Appendix E Consideration of:

Issues Raised In Submissions From Public Agencies for Stages 2B & 2C, 2D and 3B North Penrith Development Site

DA01 - Artwork locations

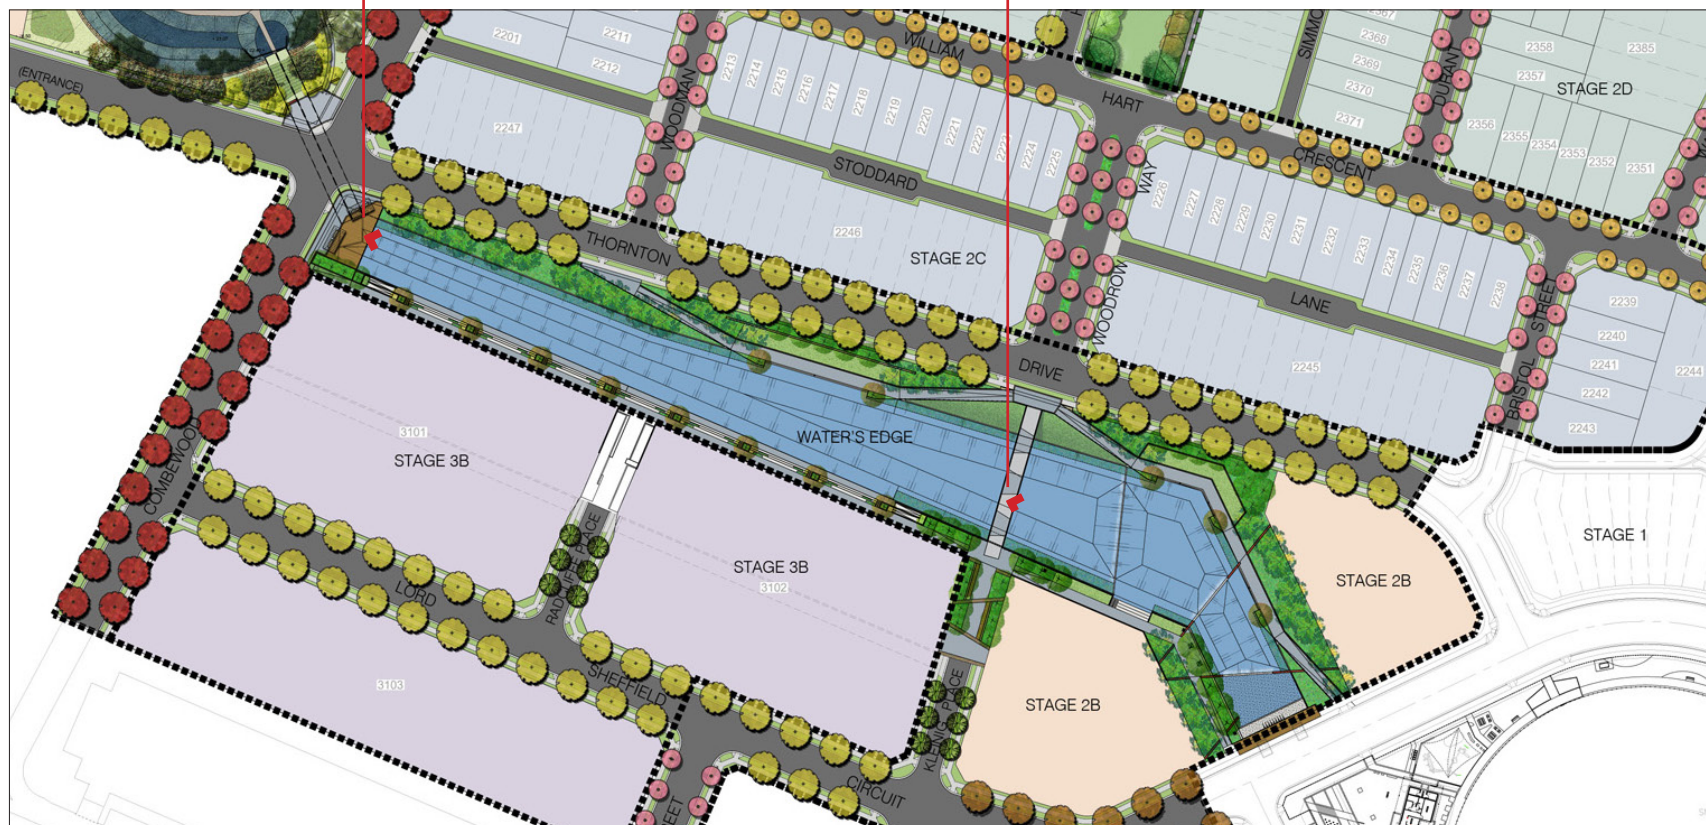
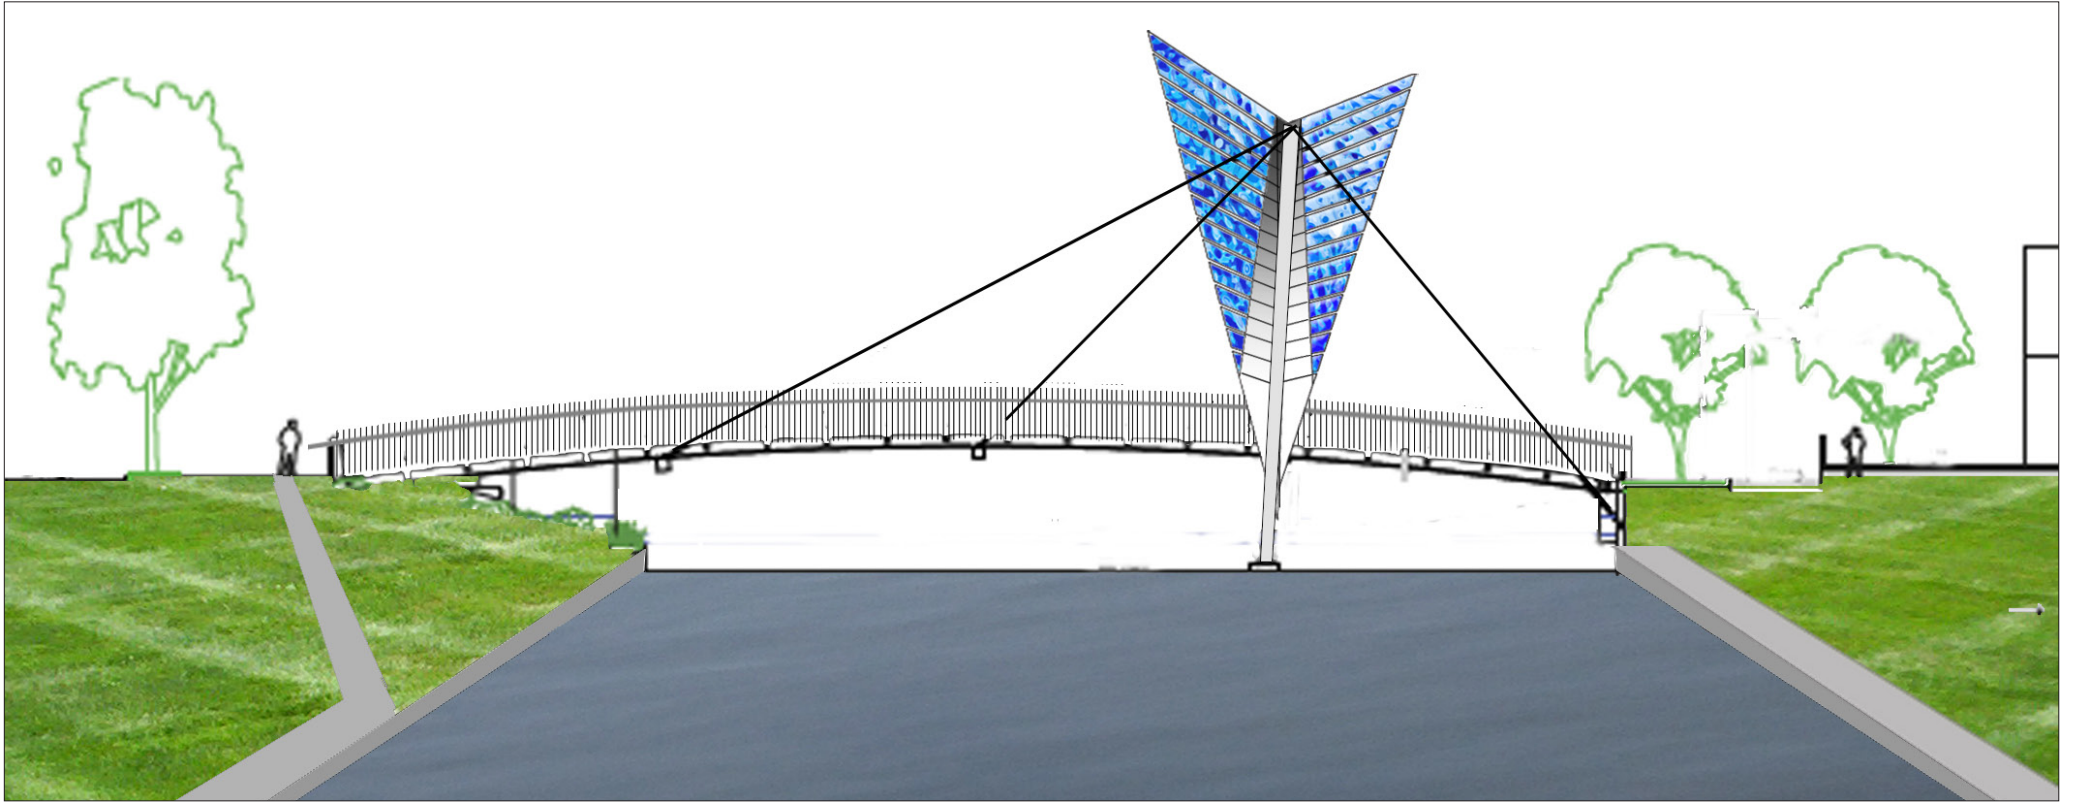
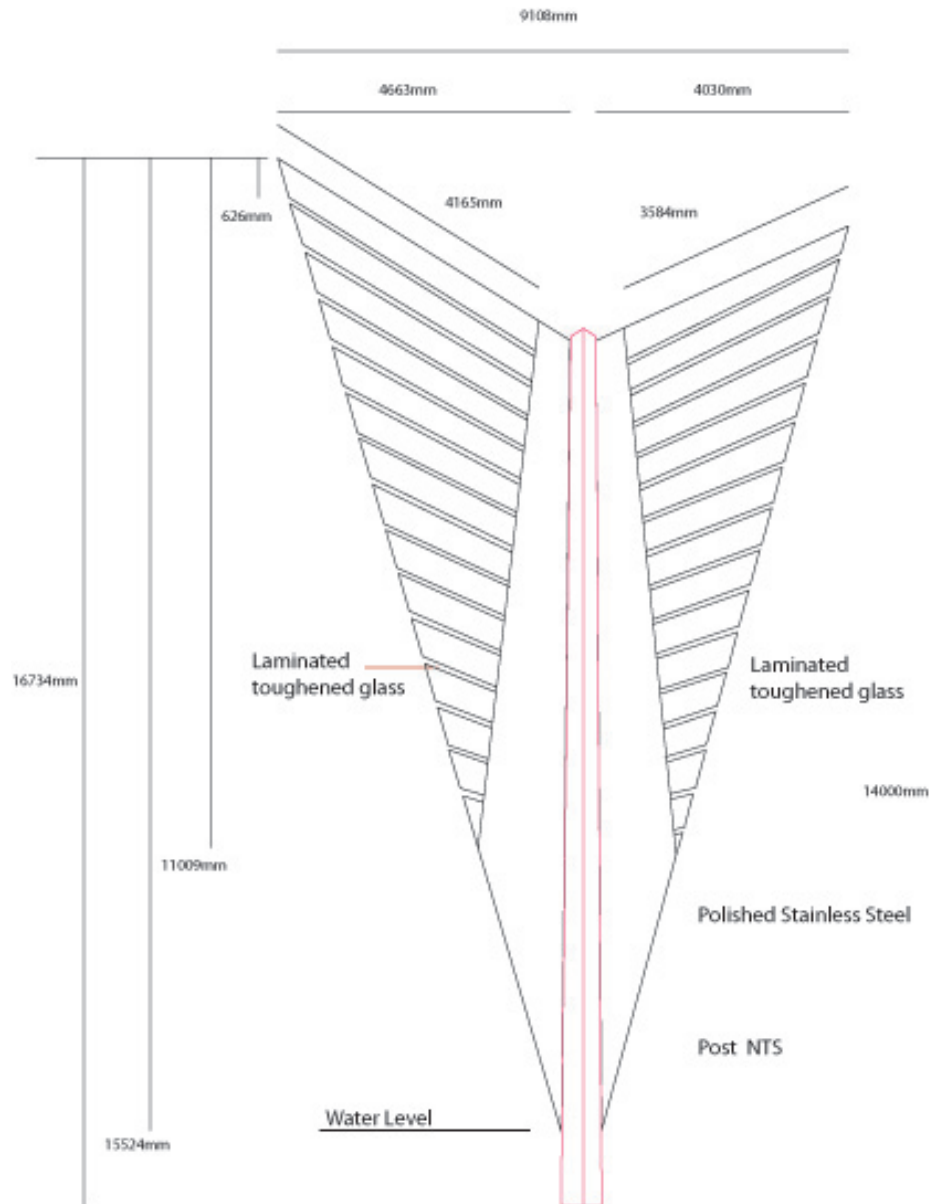
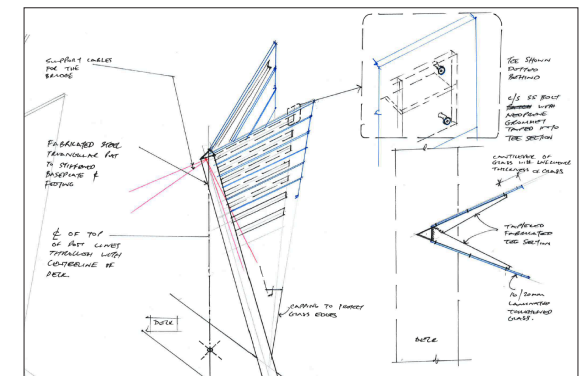
- Structural engineering details required to be provided for public art.
- List of requirements provided by Council in relation to the glass elements; and
- Art works to be inspected by Council prior to handover to Council.
